**From:** Simon Davis  
**Sent:** 27 June 2018 11:37  
**To:** Planning.Responses  
**Subject:** FW: P/49/18/HH - 39 Conway Drive Pagham

Parish Comments

Please be advised that the Parish Council planning committee met yesterday evening and would like to make the following comments regarding this application:

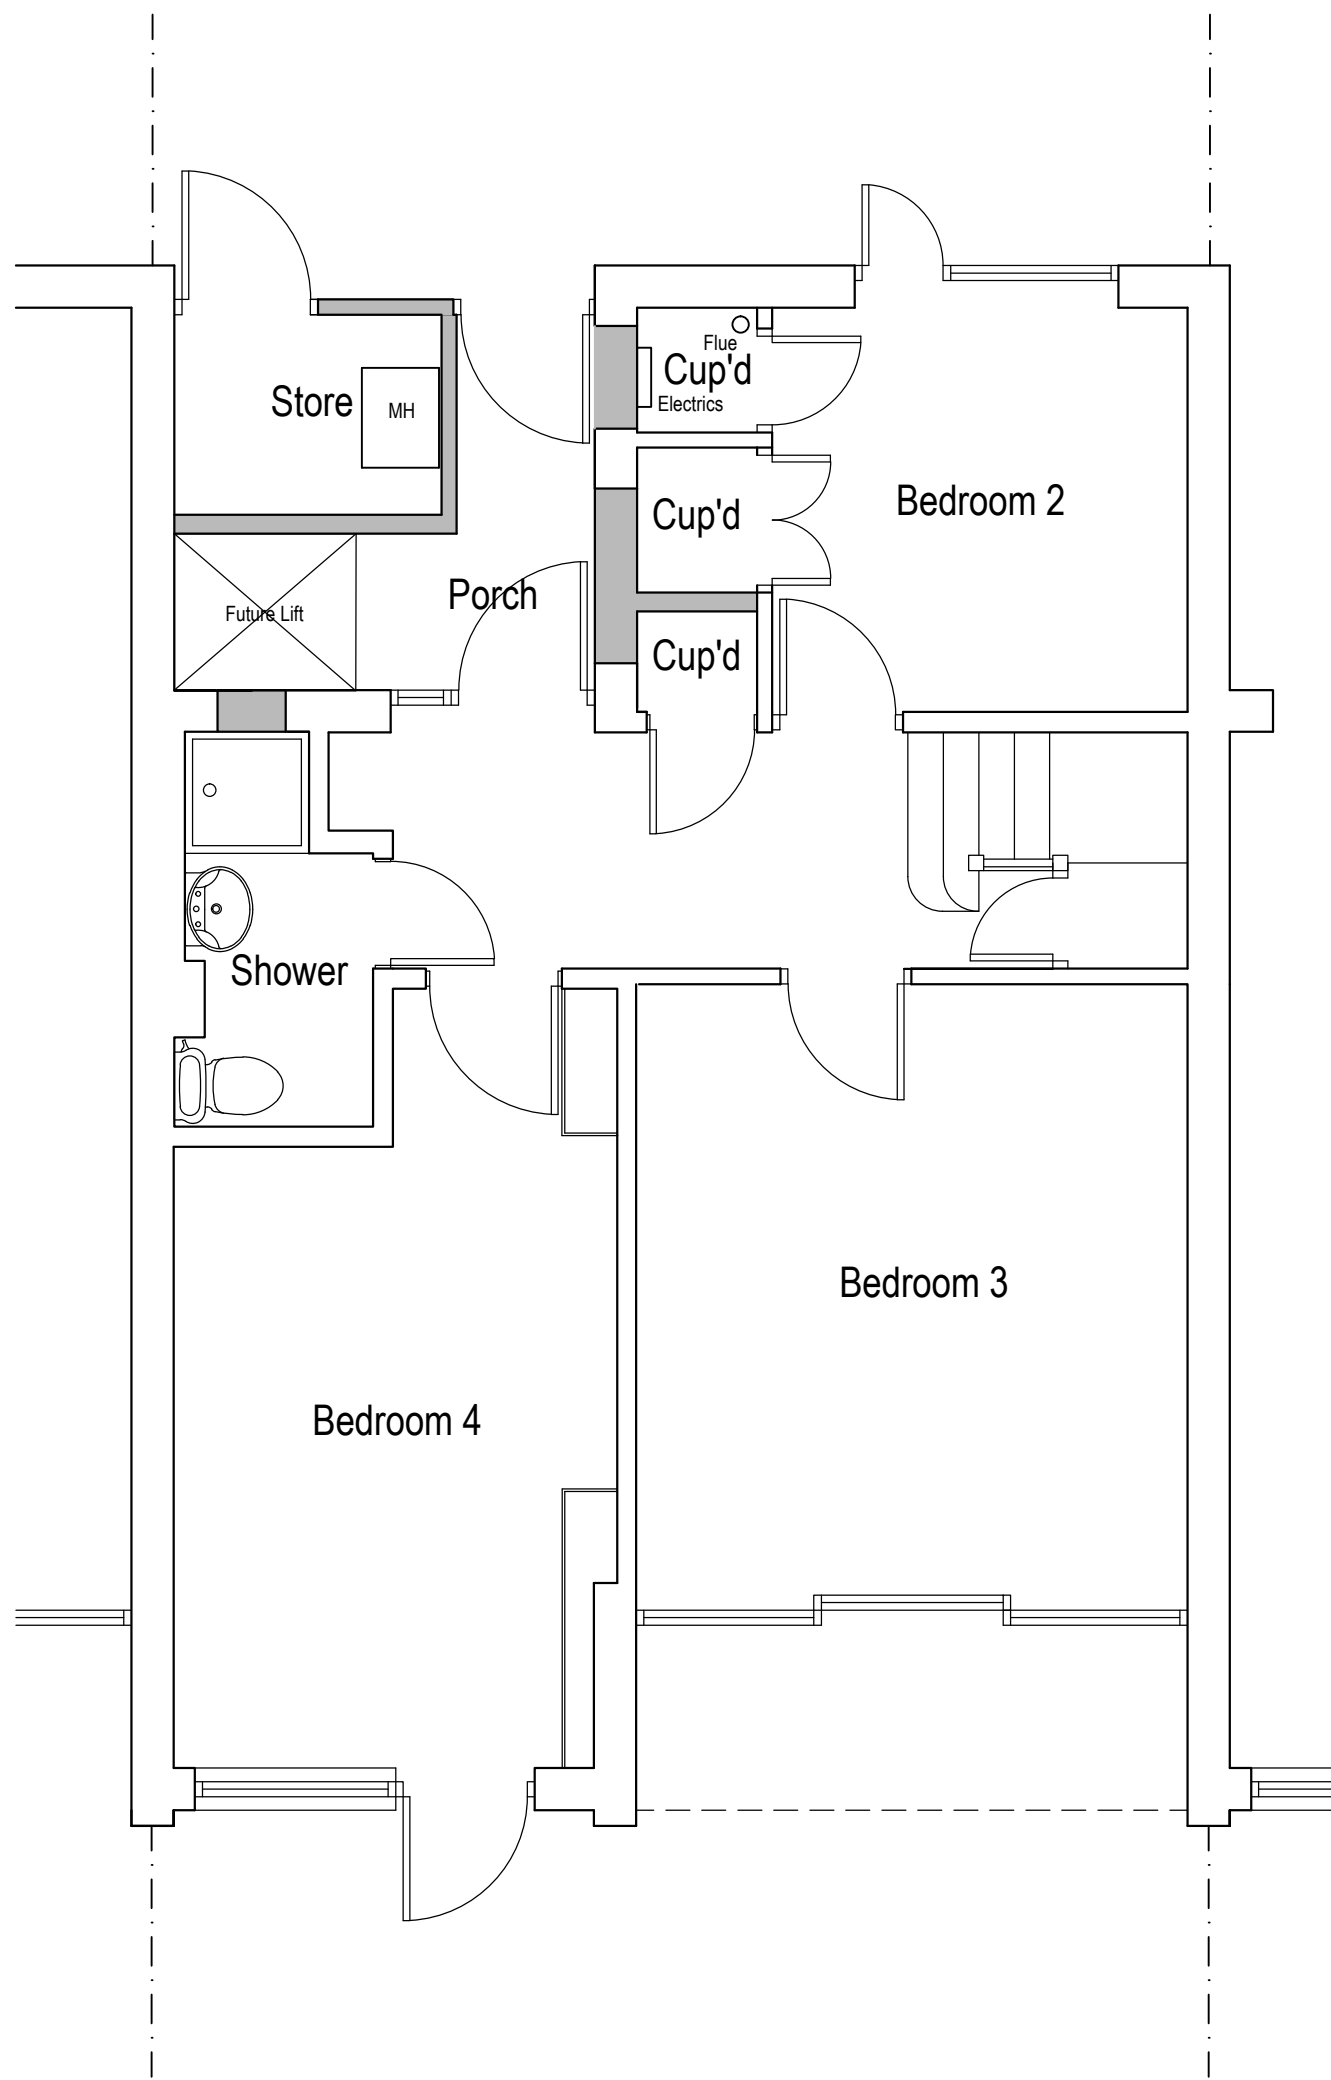
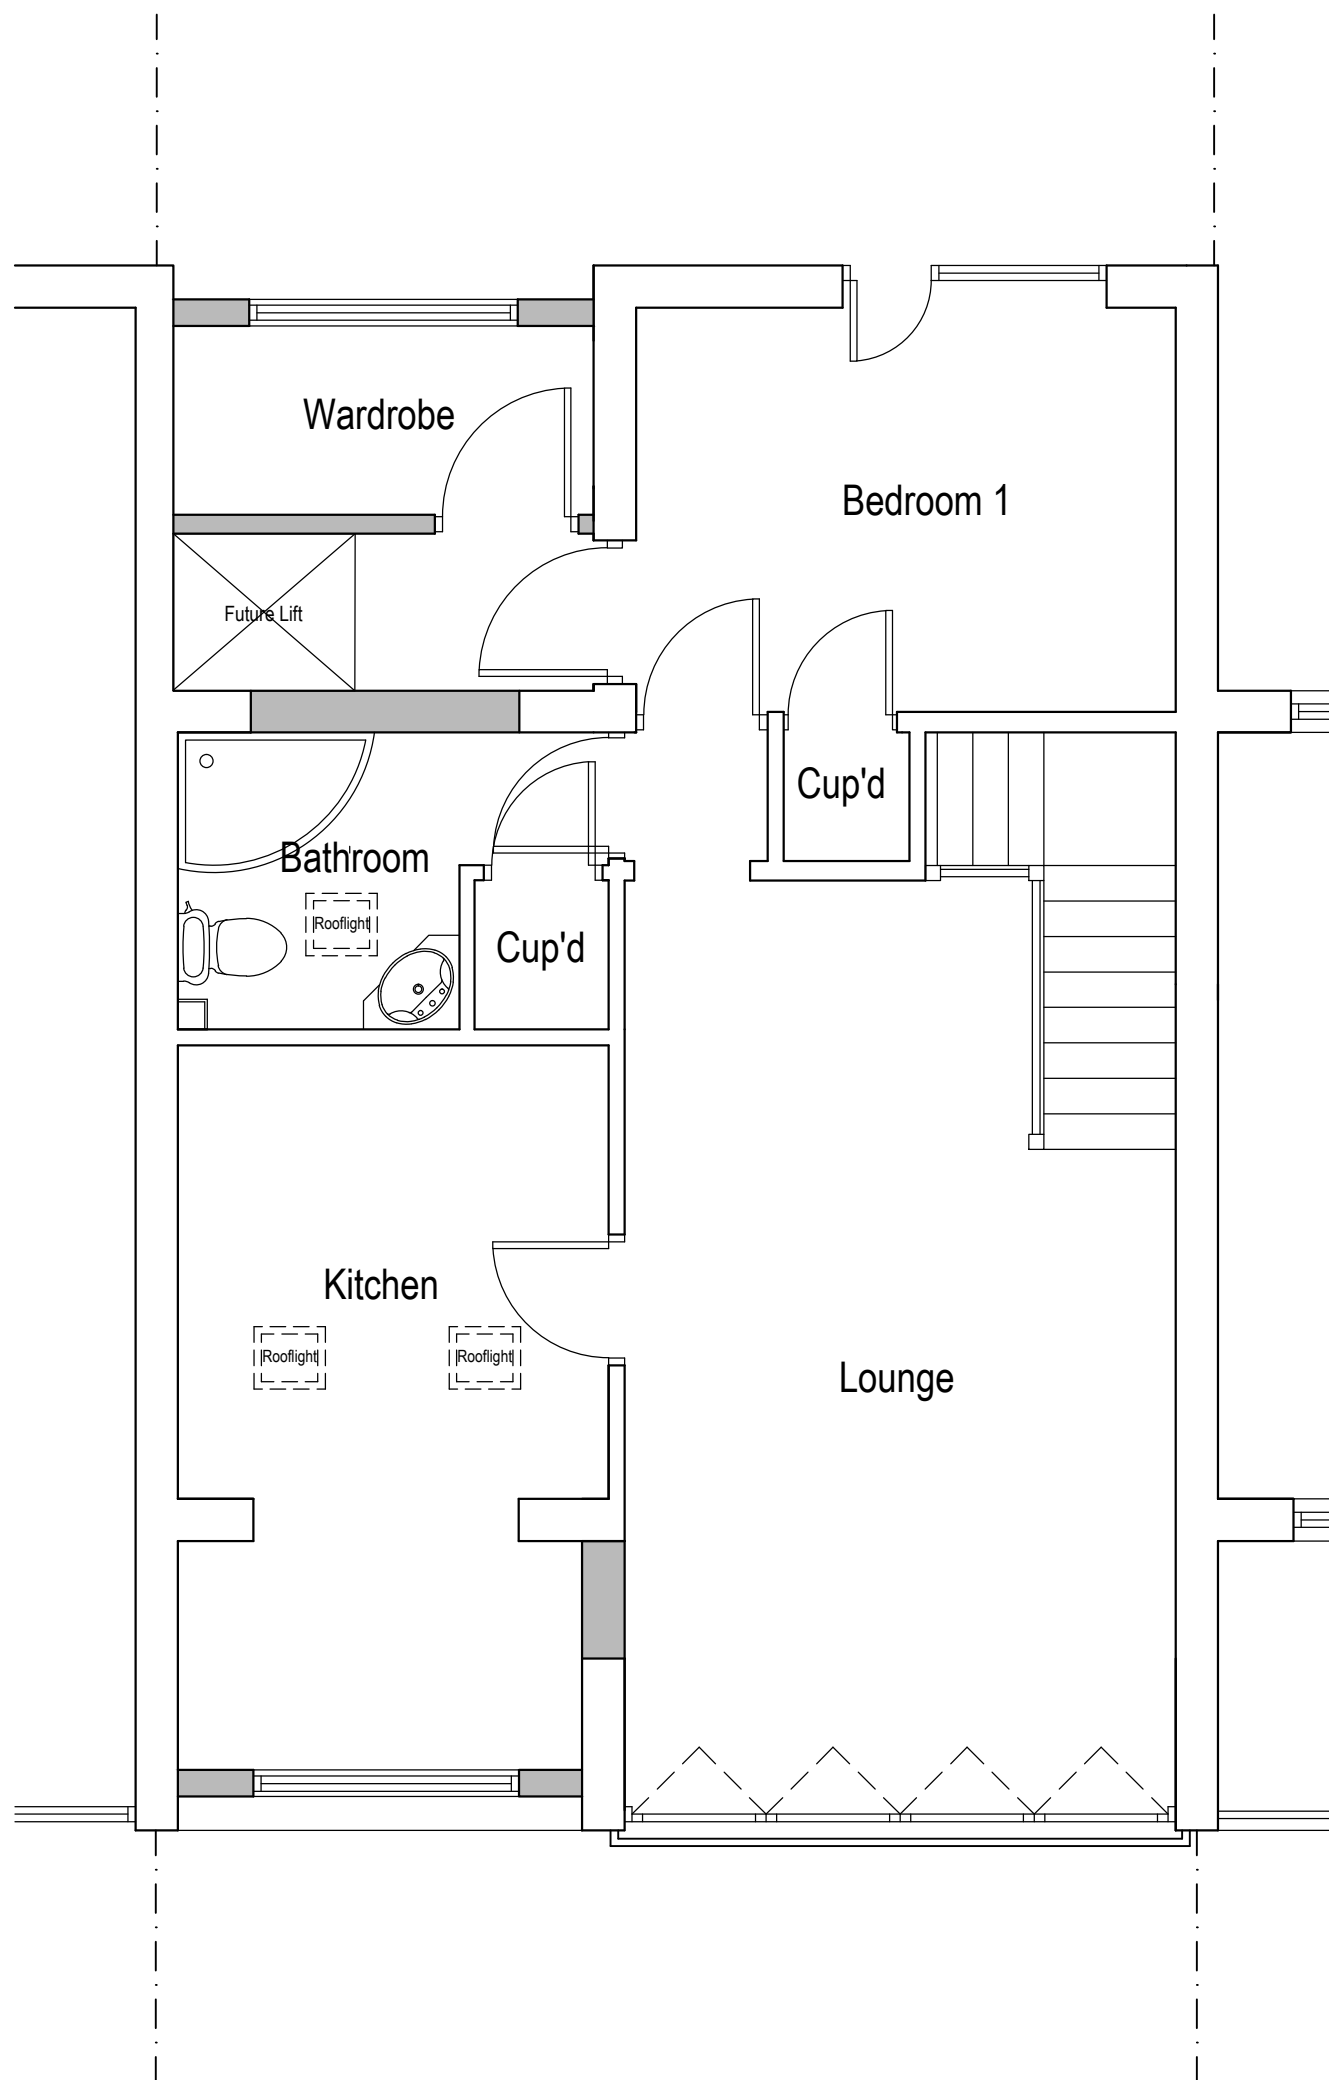
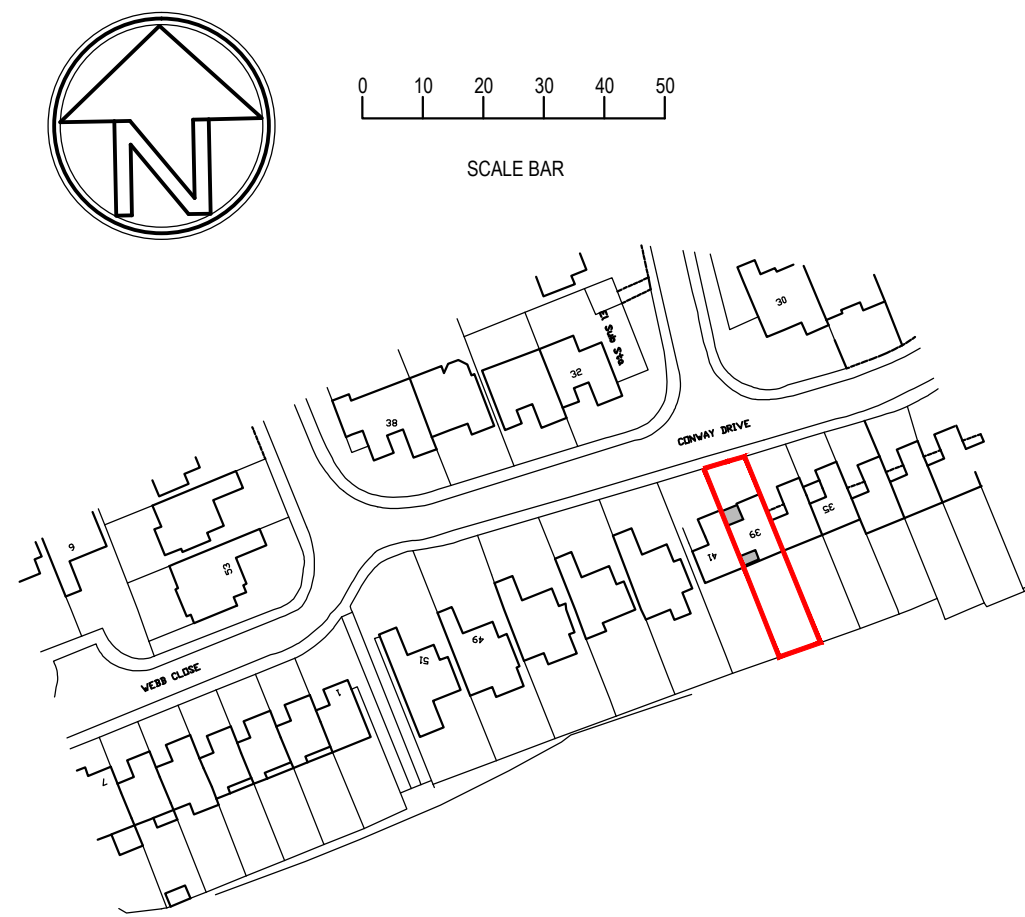
1. The proposals would be detrimental to the street scene, contrary to Policy D SP1 of the emerging Arun Local Plan. The houses are currently semi detached and this would lead to a terracing. The houses in the area are of a specific Scandinavian open design and the proposals are not in keeping with the location.
2. The proposals are contrary to the provisions of the Pagham Village Design statement, page 9 "exercise care to prevent loss of privacy in any extension or new build by virtue of existing comparatively high density link-dwelling development".
3. Concern over the noise generated from the installation of a lift against a shared wall.
4. The design is considered unneighbourly and intrusive.
